CITY OF ALBUQUERQUE

Site: Murphy Express, 1358 Wyoming Blvd NE

Re: Drainage Ordinance (14-5-2-1) Violations for Erosion and Sediment Control

SHEET NO. **C-4.1**
 JOHN H. NOURDAD
 NEW MEXICO
 PROFESSIONAL ENGINEER
 11/15/17

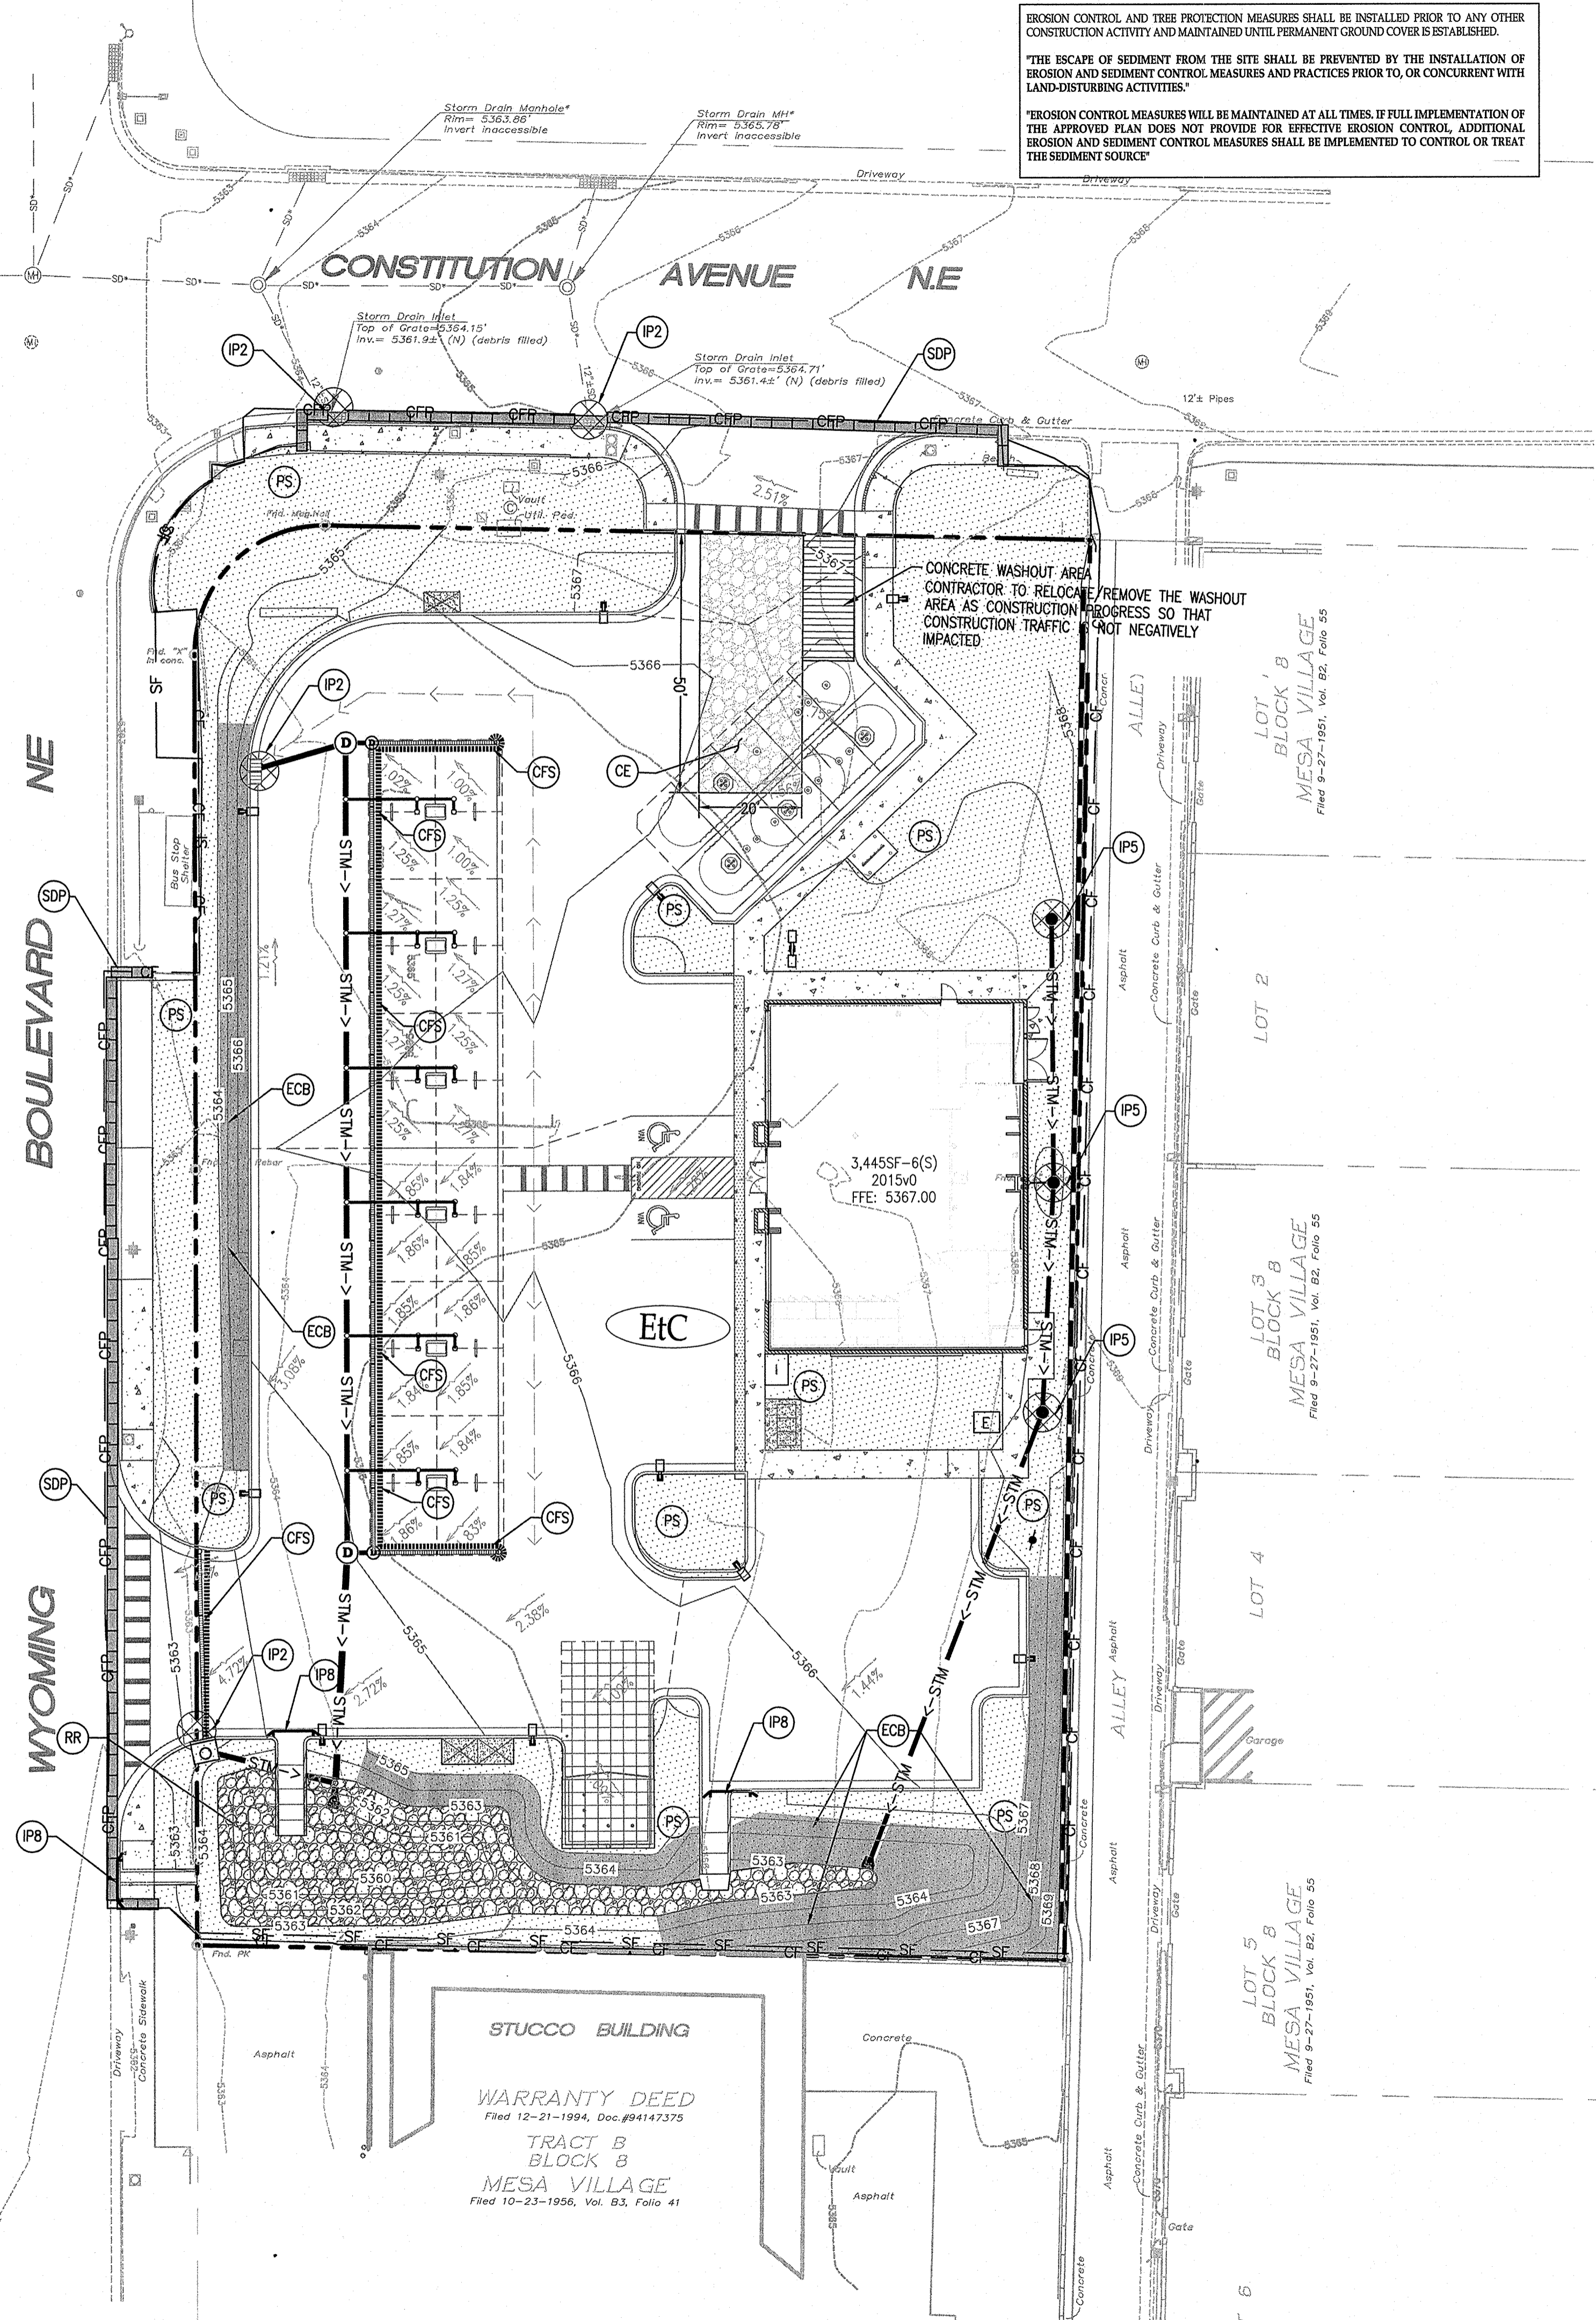
The site was not posted per paragraph 1.5 of the NPDES Construction General Permit.

1. Post the site per paragraph 1.5 of the NPDES Construction General Permit.
